**RESPONSE TO STATUTORY CONSULTEES  
HAYES PARK WEST, HAYES PARK, HILLINGDON - PLANNING REF. 12853/APP/2023/1492**

We write on behalf of our client, Shall Do Hayes Development Limited (the 'Applicant') in relation to the full planning application (Ref. 12853/APP/2025/2844) for the redevelopment of Hayes Park West, Hayes Park, Hillingdon, UB4 8FE (the 'Site').

Title: Hayes Park West – Response to LB Hillingdon Comments

Proposed Ground floor plan showing wheelchair / ambulant disabled user access to the external platform lift

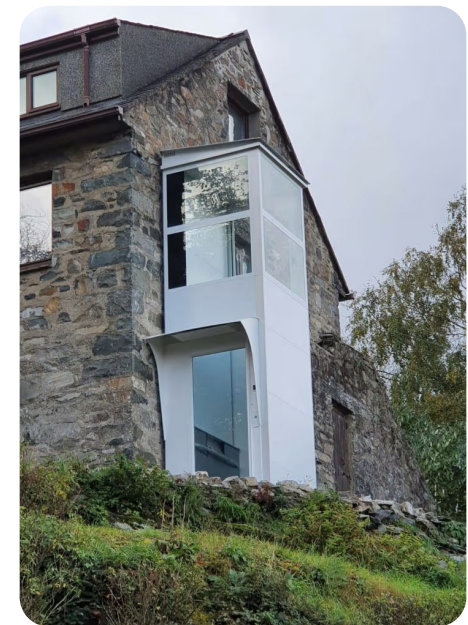
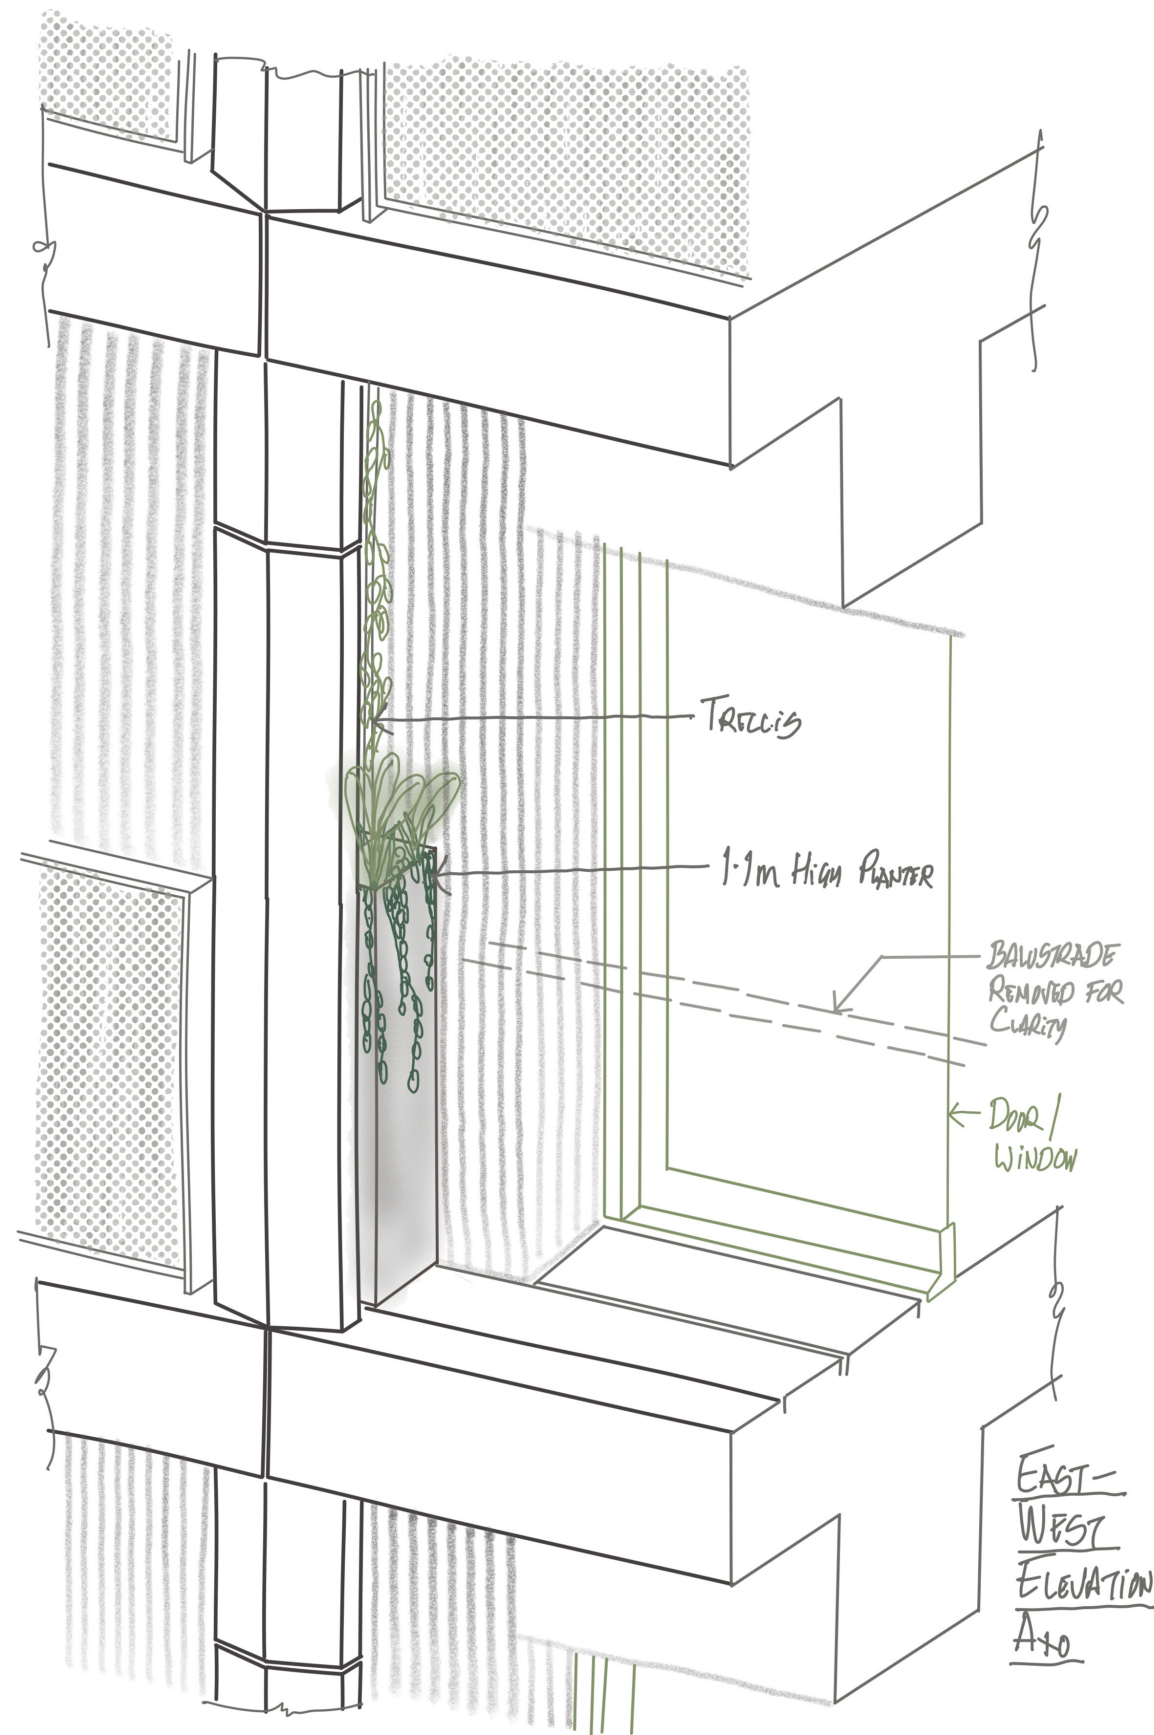
The Access Officer objects on the basis that the original submission did not include lift access and therefore did not demonstrate full compliance with London Plan Policies D5 and D7.

In response, the scheme has been amended to introduce an external platform lift providing step-free access between levels, including access to the courtyard and communal areas. The updated proposals

are illustrated within the Design and Access Statement Addendum (page 150-152) and associated drawing Refs 0489-SEW-HPW-B1-DR-A-001110 and 0489-SEW-HPW-B1-DR-A-001111.

Lower ground floor showing routes to cycle stores and visitor stands in the landscape

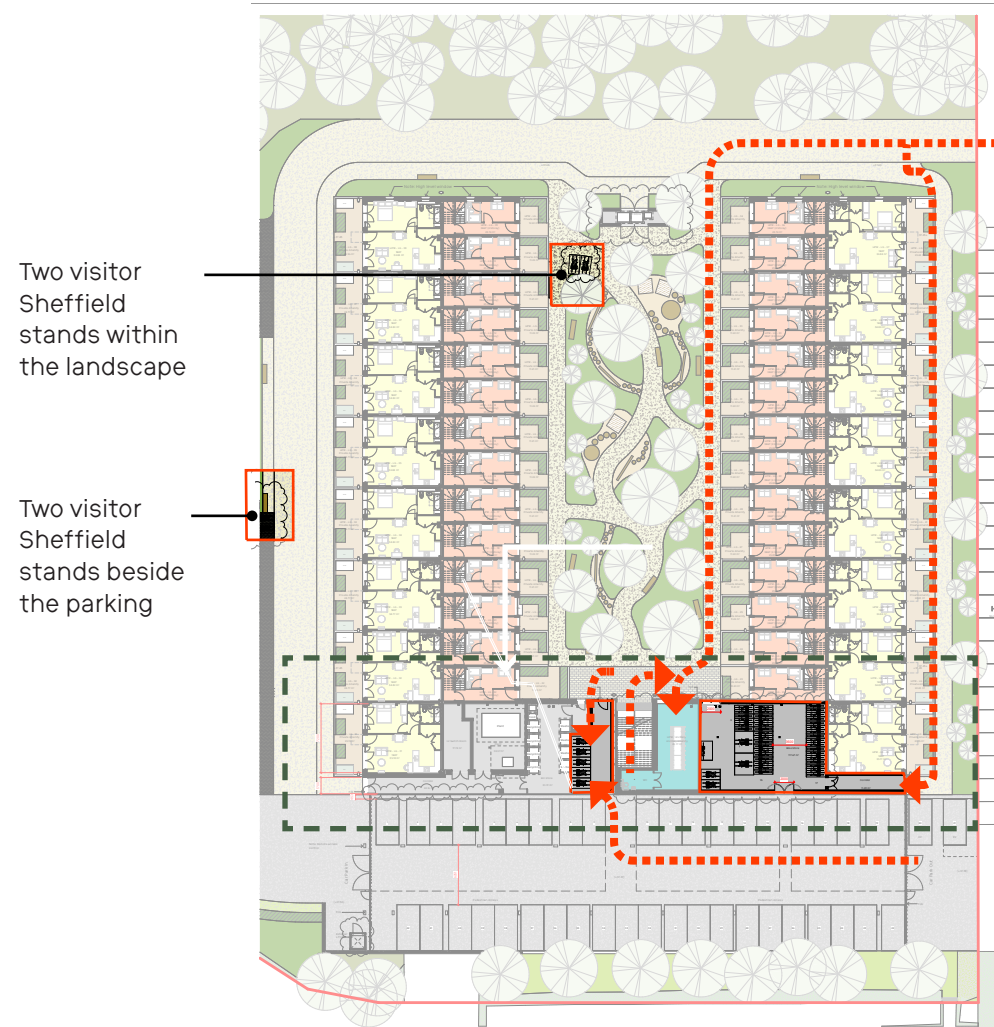
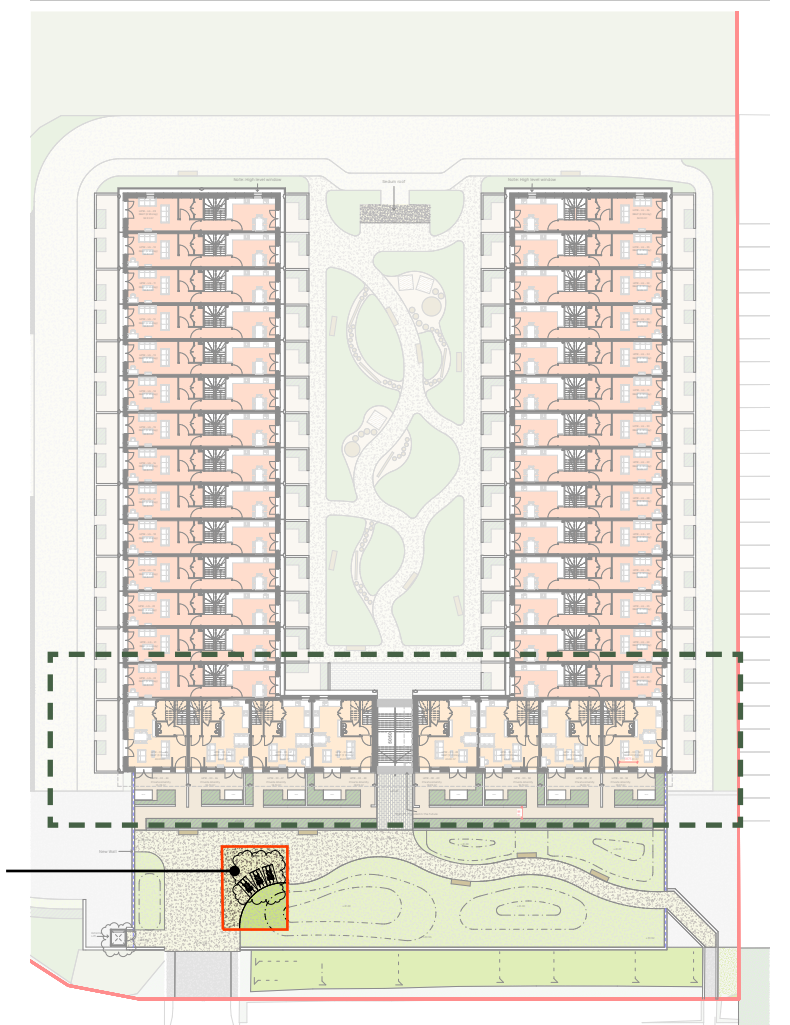
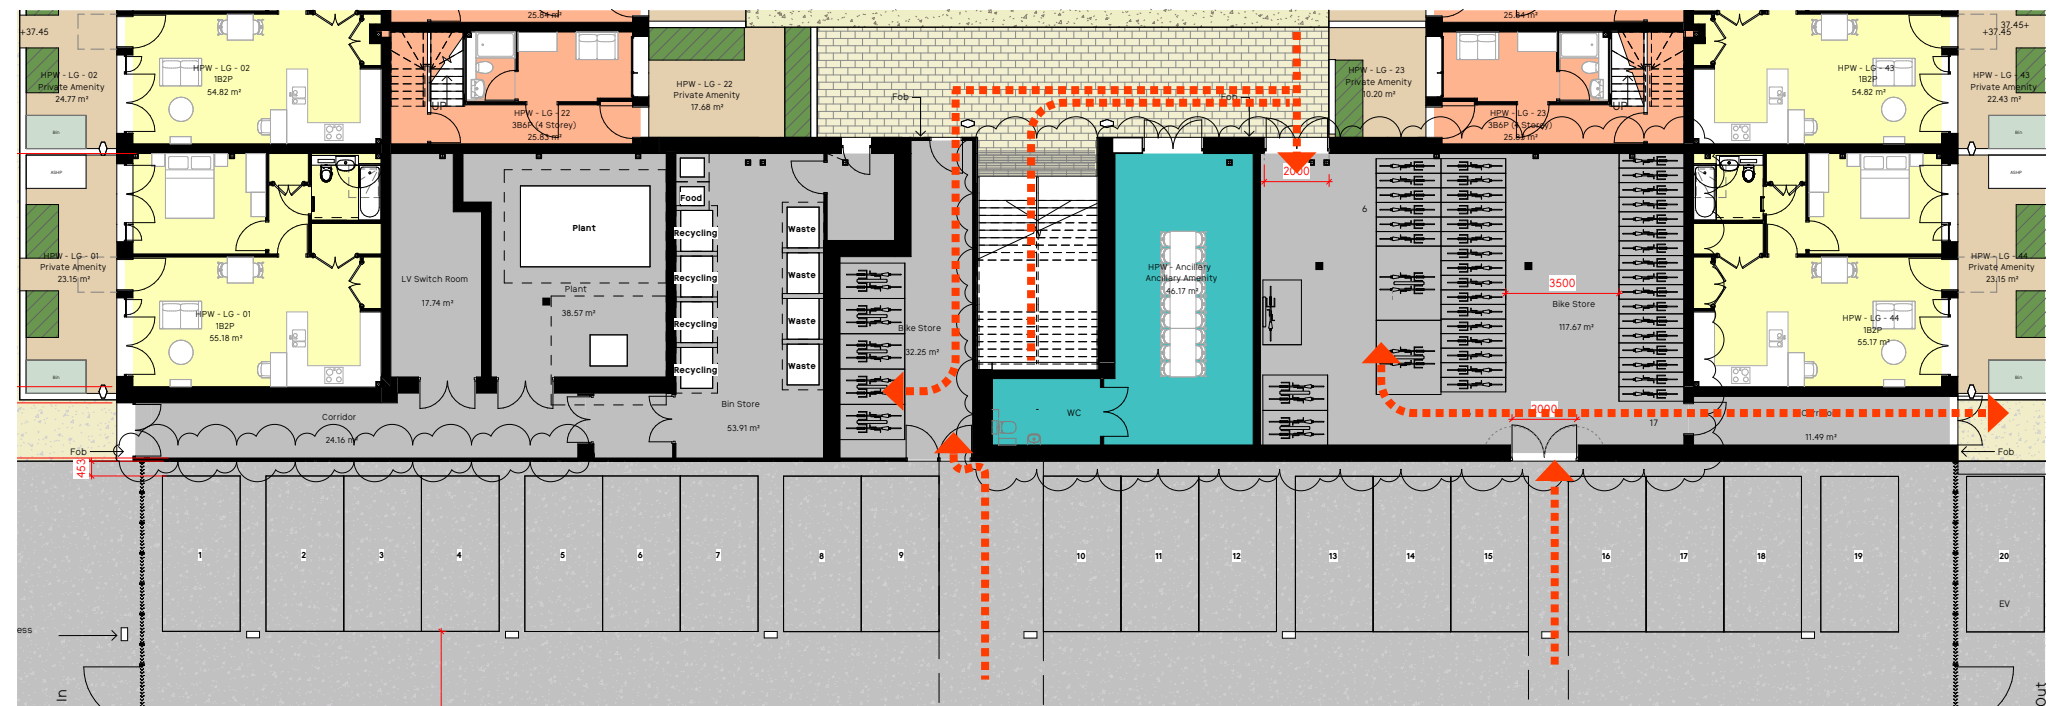
However, high-quality cycle parking is essential to support strategic modal shift. Based on the plans provided, TfL has concerns about the quality of provision. These can be summarised as:

- External door widths are currently shown as 1m; these should be a minimum of 2m, particularly as enlarged cycle spaces are located within these areas.
- Ideally, cycle stores should have a clear width of 3,500mm to accommodate double-stacking racks effectively.
- Where Sheffield stands are provided, the minimum centre-to-centre spacing must be 800mm to ensure usability.
- Short-stay spaces should be clearly identified on drawings and located within 15m of main entrances to ensure genuine usability of the spaces.

An updated plan has been produced by SEW (page 159 of the attached addendum), the architects, showing changes to the cycle

stores in order to be LCDS compliant. This demonstrates doors are 2m wide, that there is a clear width within the cycle store of 2.5m, which is the minimum allowed, 800mm between Sheffield Stands and highlights the location of short stay spaces as requested.

Planning Policy Query: Built Volume Comparison - Between existing carpark structure and proposals

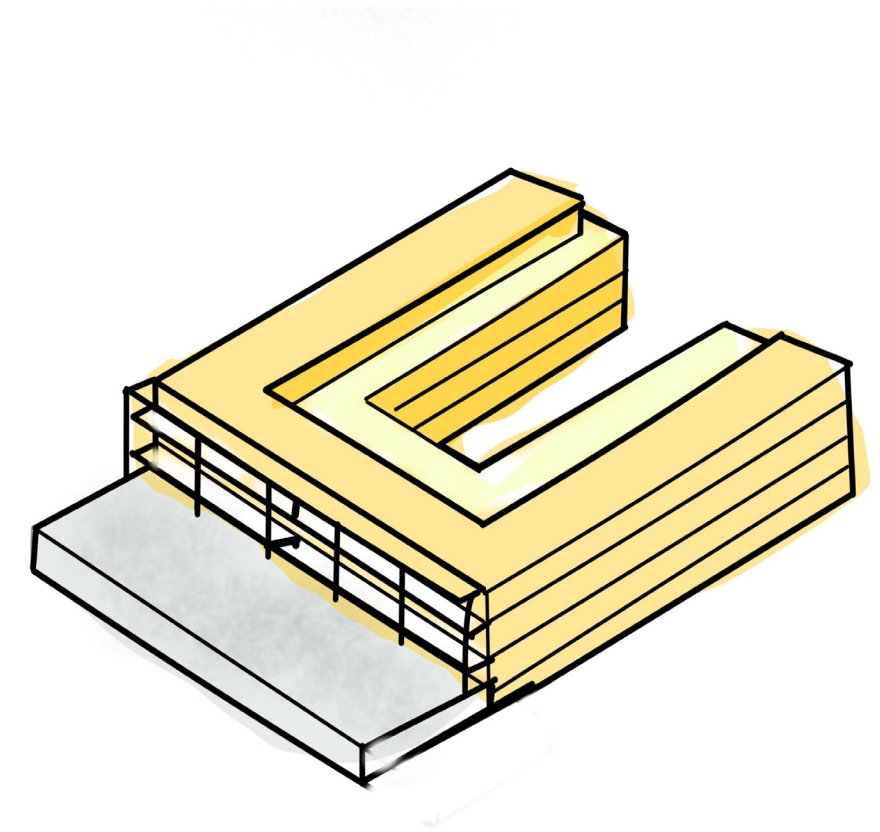
The Planning Policy Team requests clarification in relation to verified views, full trip generation data and built volume comparison.

A built volume comparison between the existing car park and the proposed development is provided within the Design and Access Statement Addendum (page 160), which identifies the existing volume of 15,652 cubic metres and proposed volume of 29,208 cubic metres. This results in a 54% increase in built volume.
